Immingham Green Energy Terminal – TR030008

Section 51 advice regarding draft application documents submitted by Associated British Ports by 23 May 2023

GH Project Number	Scale at A3
201566.00001	1:2,500
Drawing Number	Revision
GH-20156600001-LP-4	1

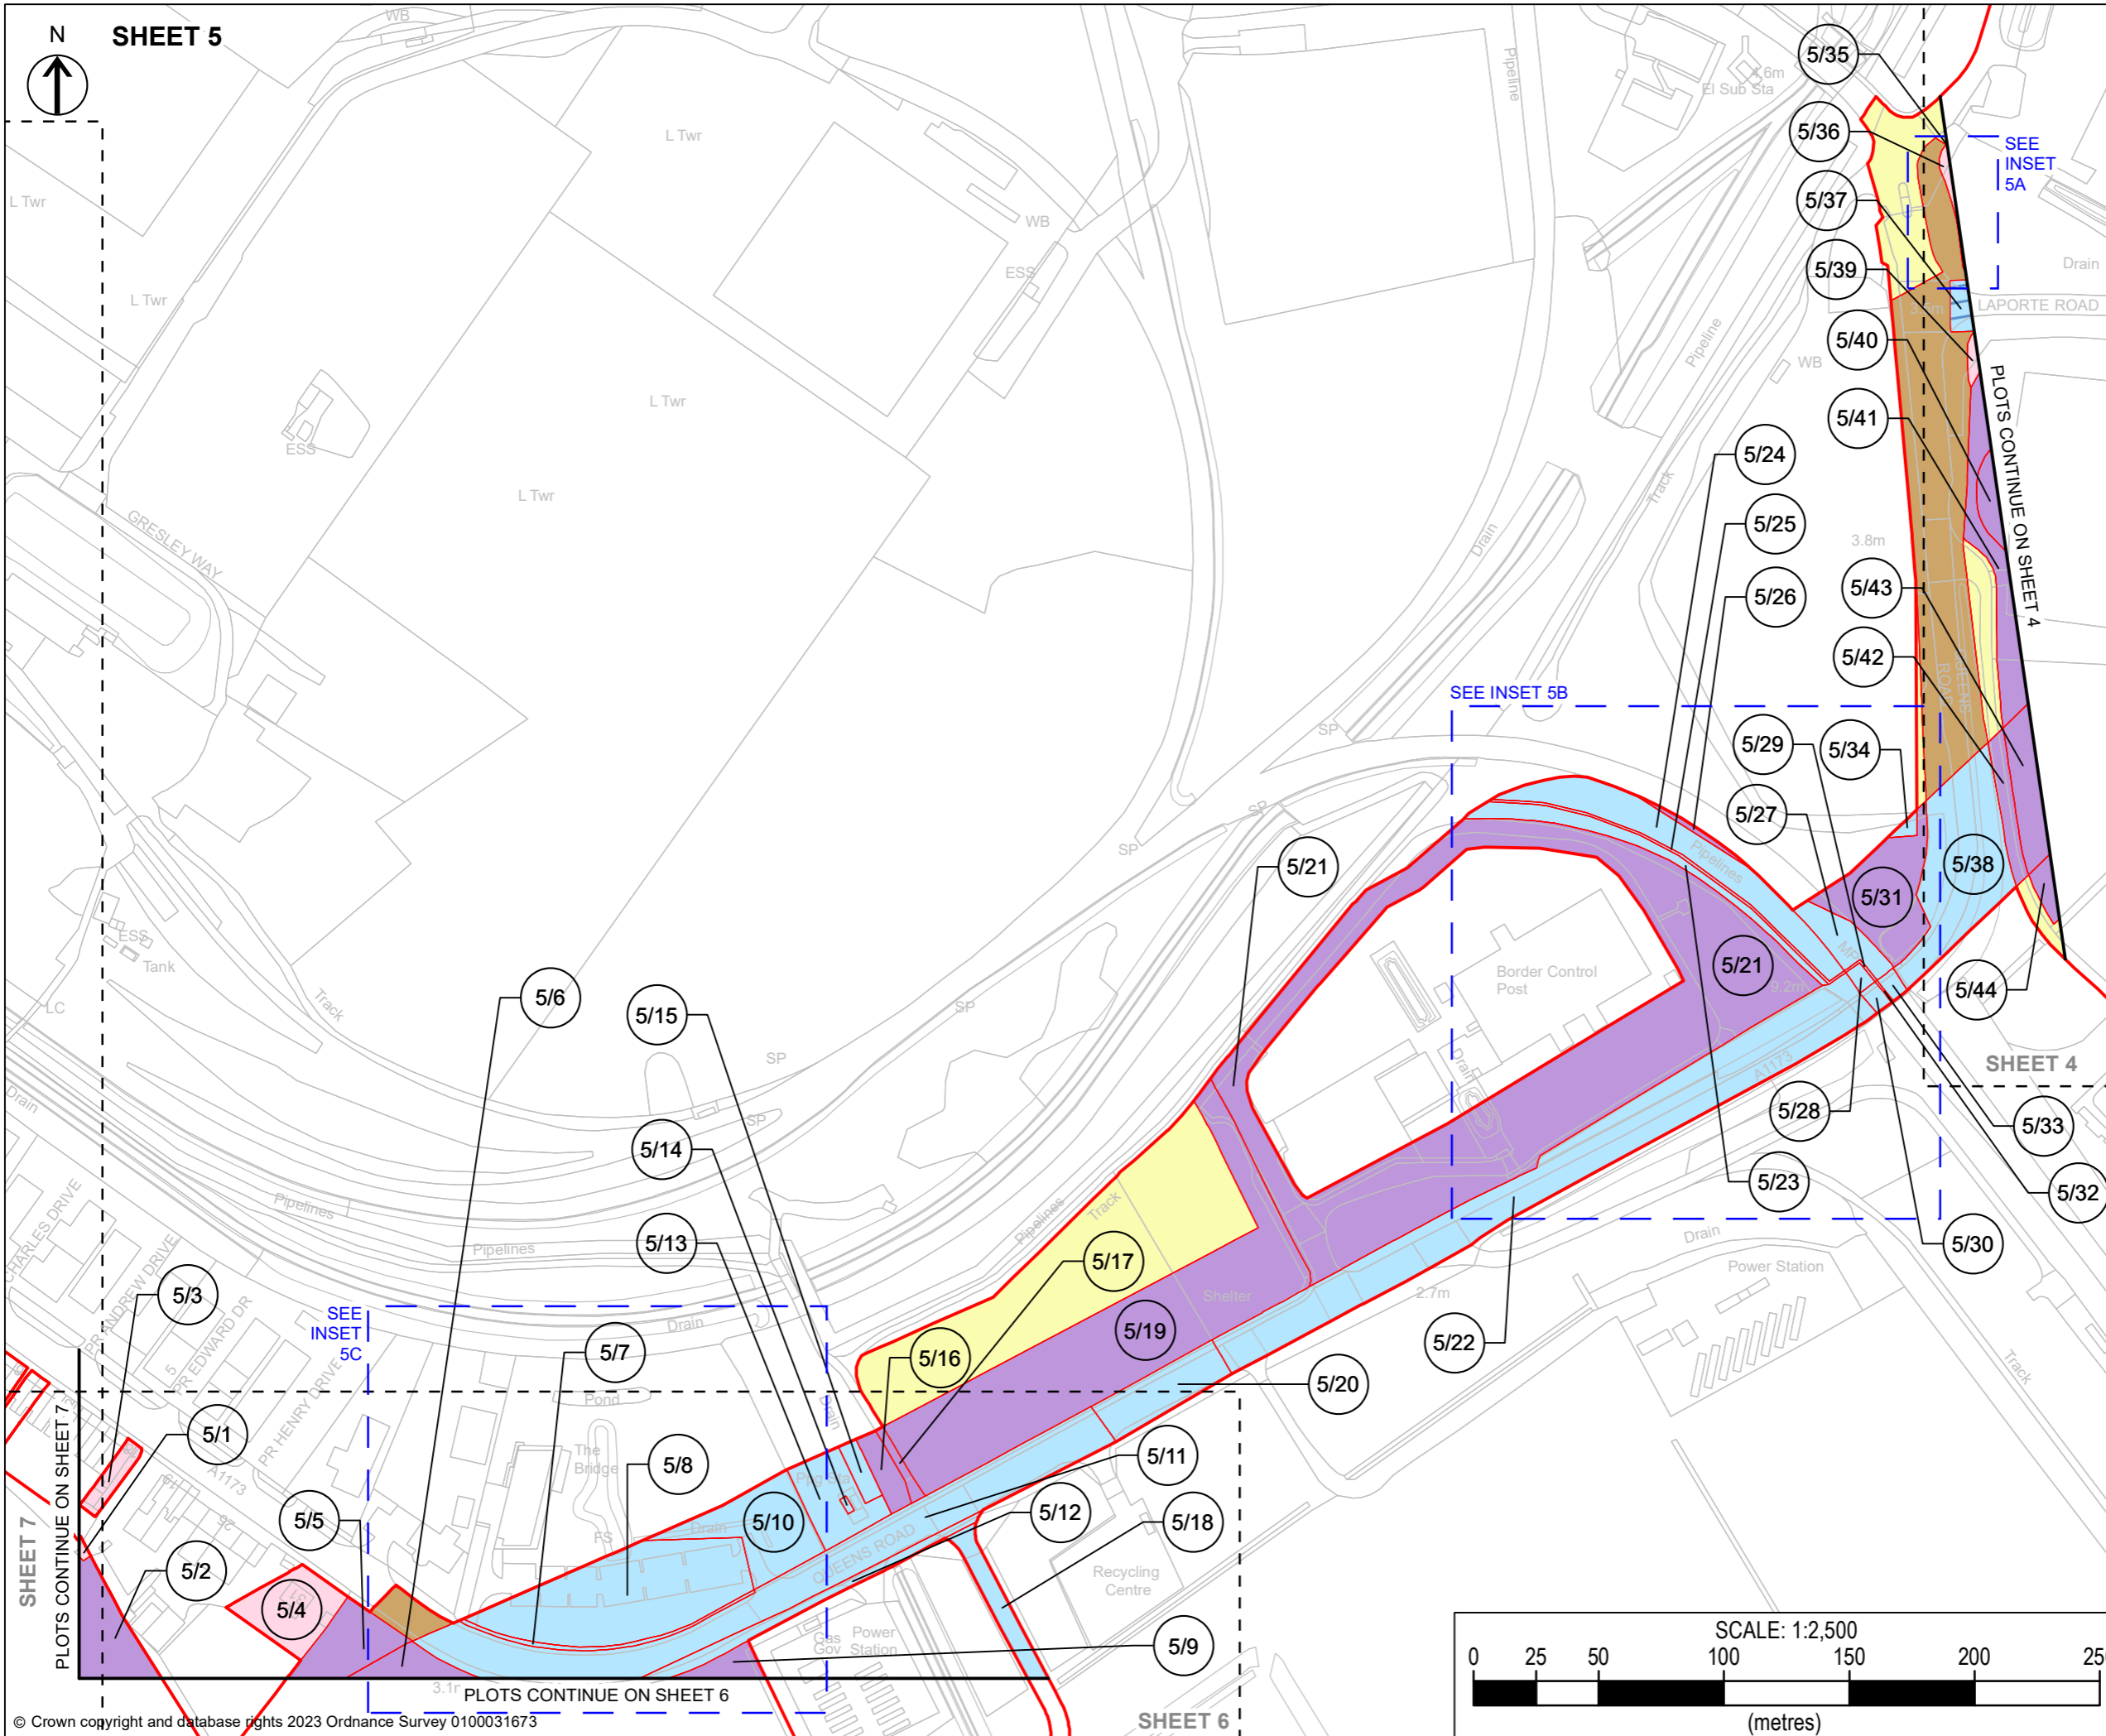
32.	Sheet 4 of 6	<p>Upon review, this sheet does not correspond to the Key Plan and the land parcels that are expected to be illustrated on this sheet. It would be beneficial if the location plan could include the red-line boundary to make this clear.</p> <p>It is standard practice for “Insets” to be located on the sheet to which the land parcels relate. If the Applicant wishes to illustrate this on a separate sheet, it would assist the reader if this was provided or inserted immediately of the sheet it relates to.</p> <p>We draw your attention to paragraph 23 of the application form guidance as noted above at Ref No.27. The applicant may wish to consider reviewing the information depicted on this plan and consider the best means on illustrating the insets included.</p>

33.	Sheet 4 of 6	Very busy and a little difficult to read and understand given the number of lines and plots. However, the plan indicates that there are insets which do help (4A and 4B). Could this be made clearer in any way, perhaps by increasing the number of insets.

34.	Sheet 4 of 6	Plots 4/53 and 4/63 appear to be the same plot on the Land plan and attention is drawn to the application form guidance regarding this matter.

Drawing Number
 GH-20156600001-LP-5
 Revision
 1

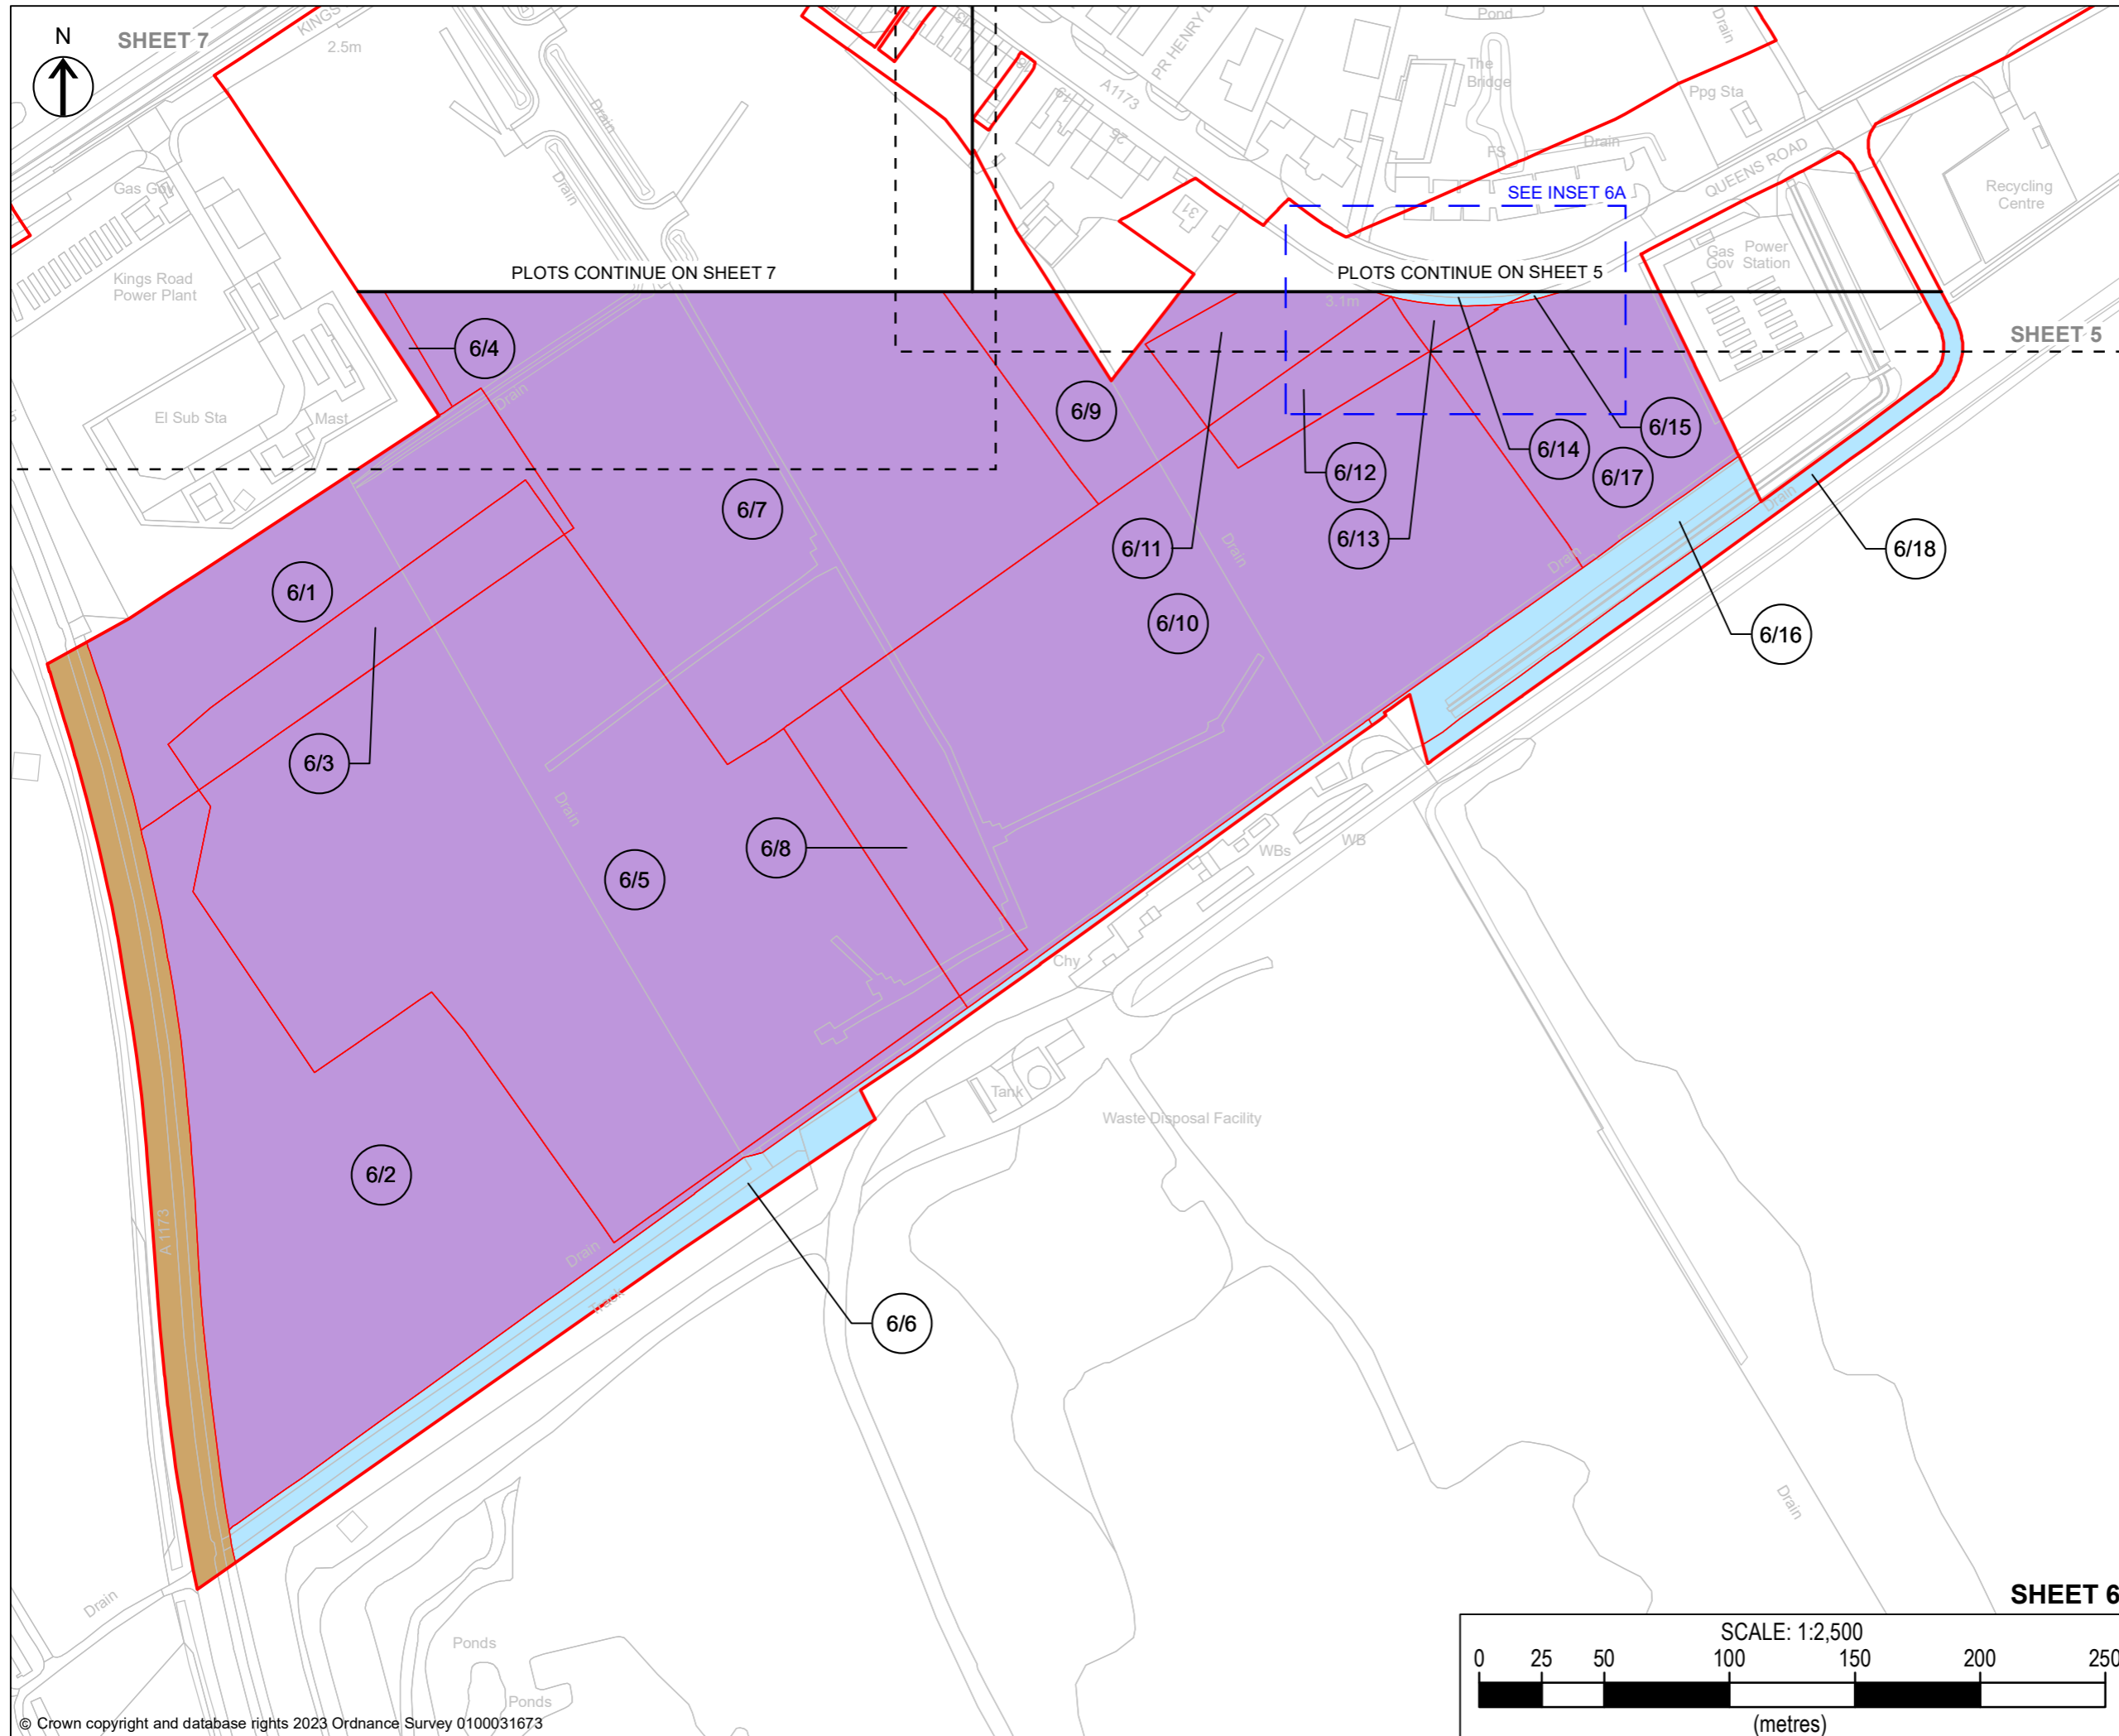
35.	Sheet 5 of 6	Plot 5/9 as described in the BoR indicates that this plot is “east of A1173”, however, this is only referenced on the plan in the top left corner showing the A1173 to be north of this plot. Is the road running down the left-hand side of the plan the A1173 continued? (Not shown on sheet 6 of 6 either).
